RE: West Mesa Ridge TIS, Albuquerque, NM

We are in receipt of your comments on the above-mentioned Traffic Impact Study (TIS). Please find a summarization of our responses to your comments below:

NMDOT Report Comments

Figure 2. West Mesa Ridge Site Plan

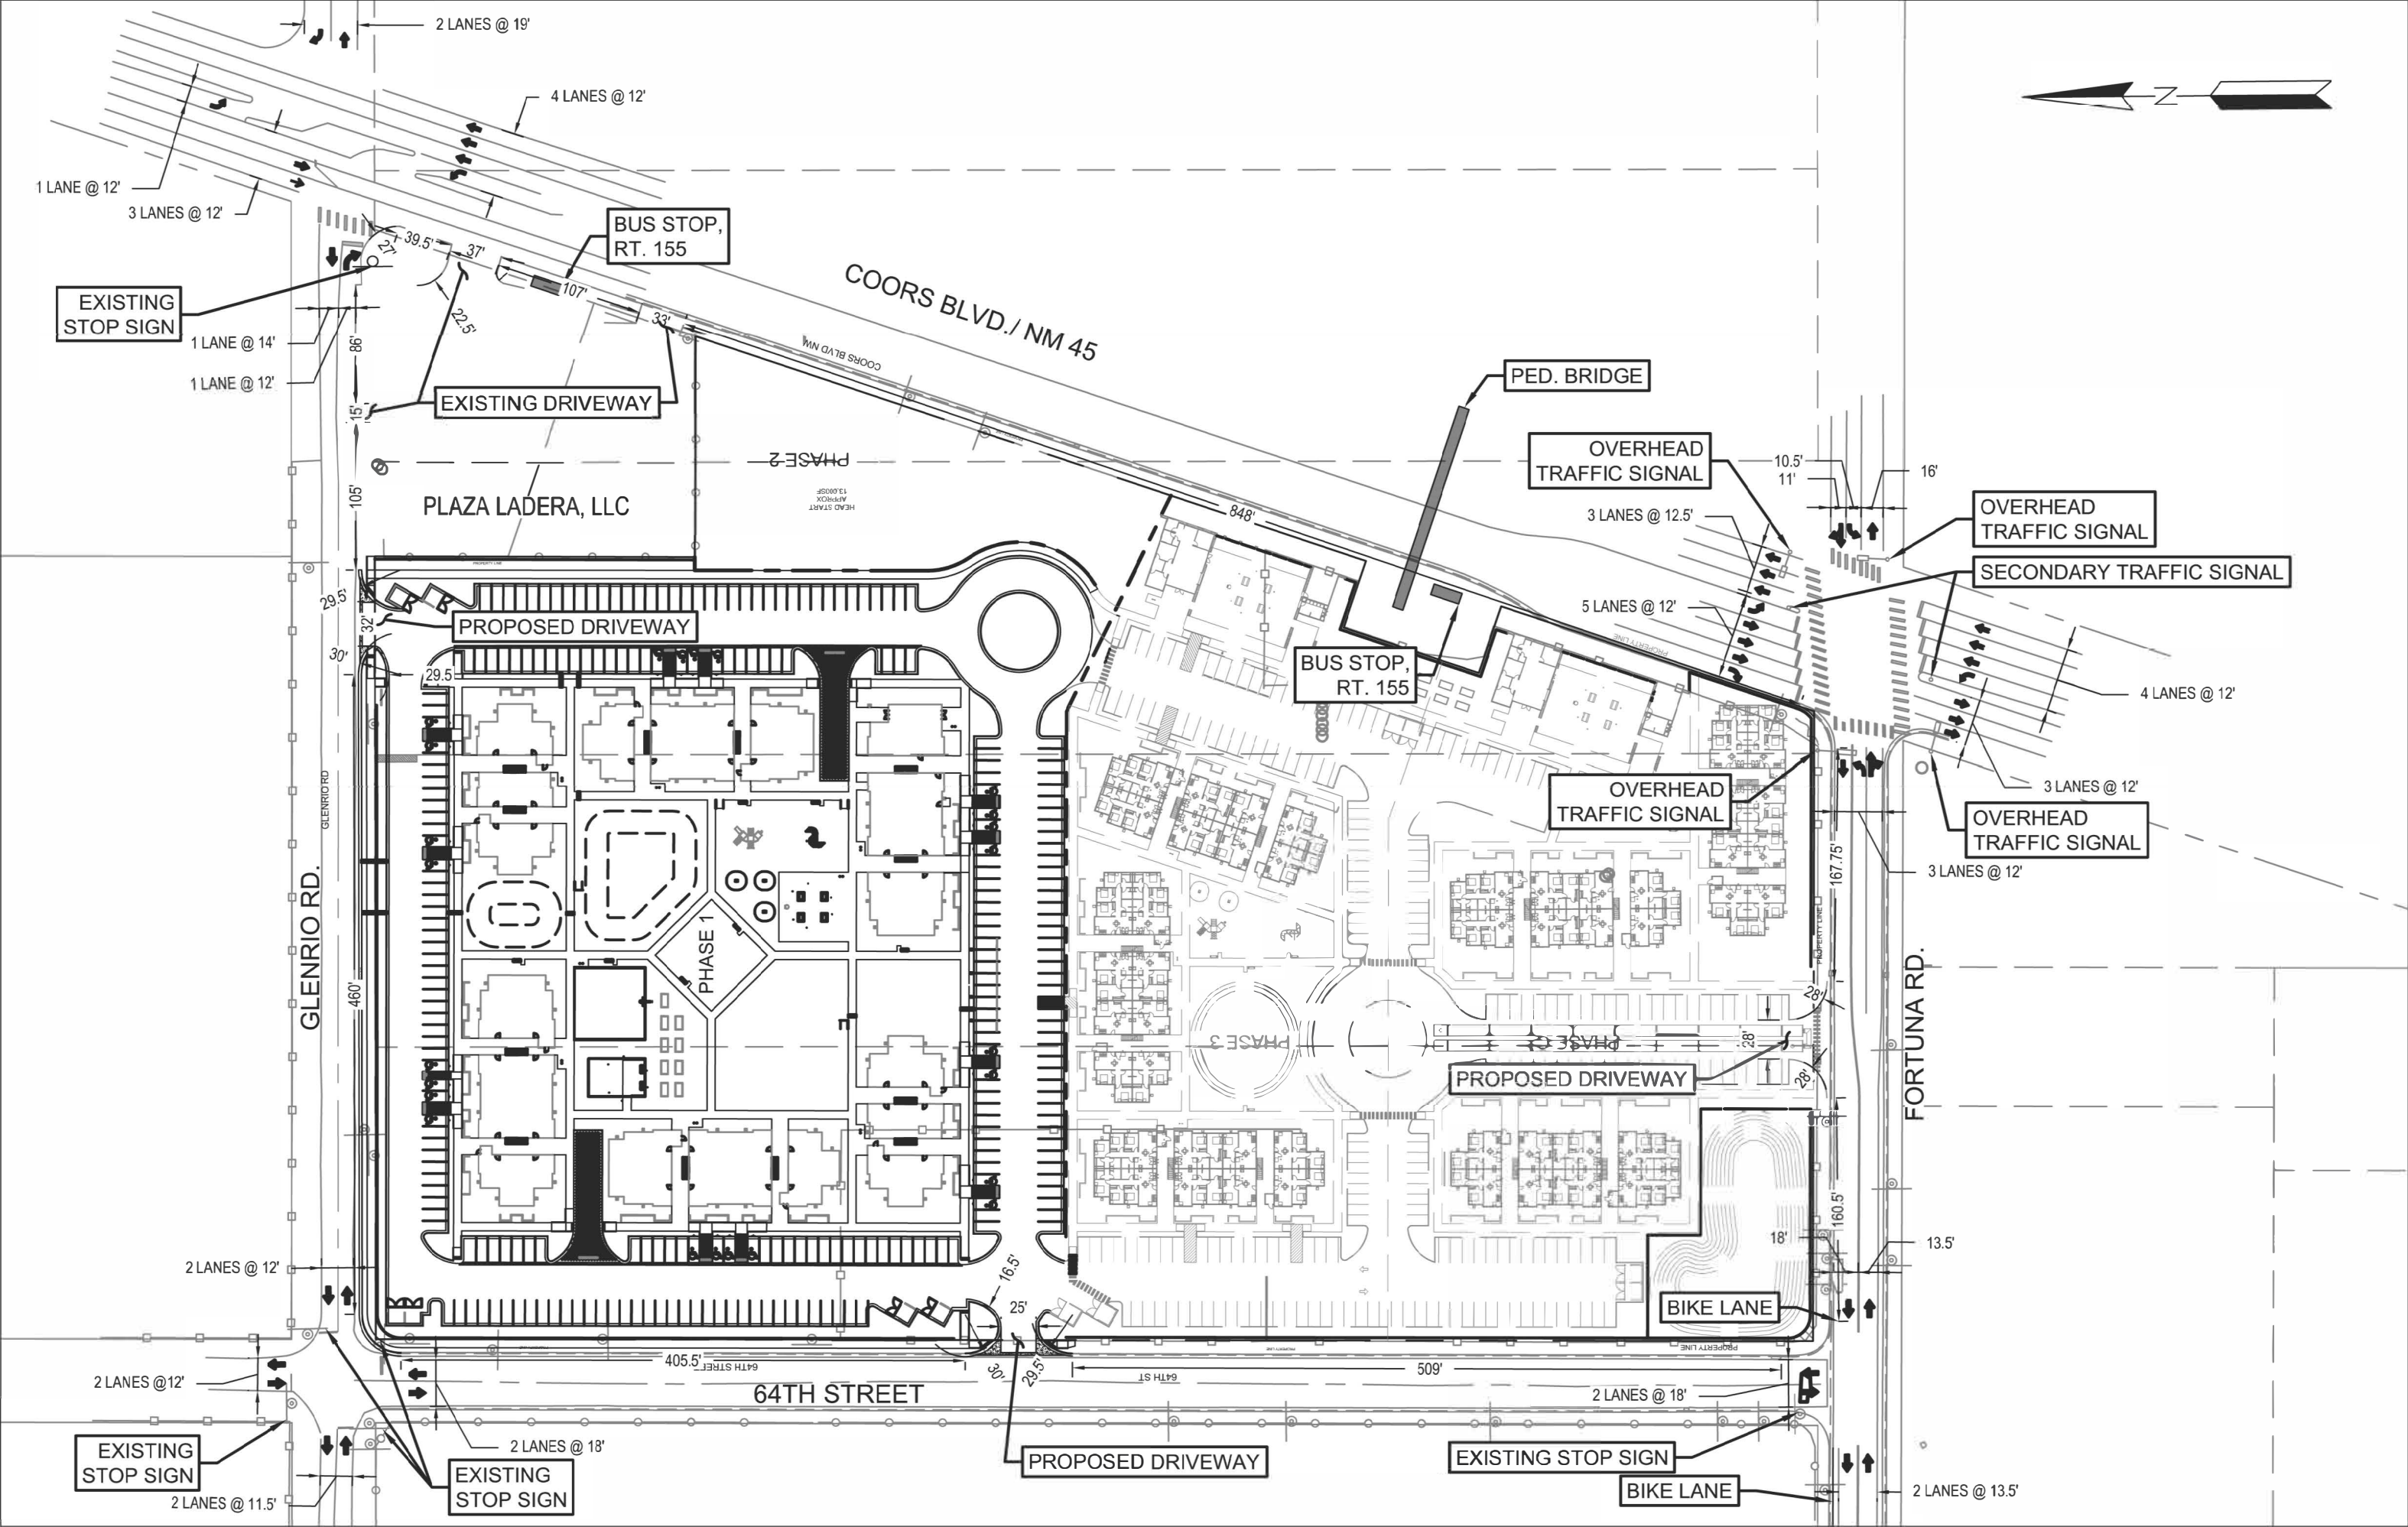
The walking distance across the Fortuna Rd. entrance should be shorter or include a pedestrian refuge.

Reduce radii at all entrances to 15'. This will shorten pedestrian paths and may require a slow drivers.

The proposed driveway is a typical commercial driveway width. Reducing the driveway throat may cause potential conflicts between design vehicles (ingress/egress). The site is designed to accommodate a fire truck. Constructing a pedestrian refuge island may require a gap to be constructed in island for ADA accessibility and may have similar conflict considerations for design vehicles. This modification is not recommended.

Reducing the radii to 15' at each of the driveways will shorten the distance pedestrians cross in the driveway a little. However, this may create scenarios where fire trucks may not be able to make the turn without driving over the curb, sidewalk, or encroaching into the egress movement. The proposed driveway radii are designed for a fire truck.
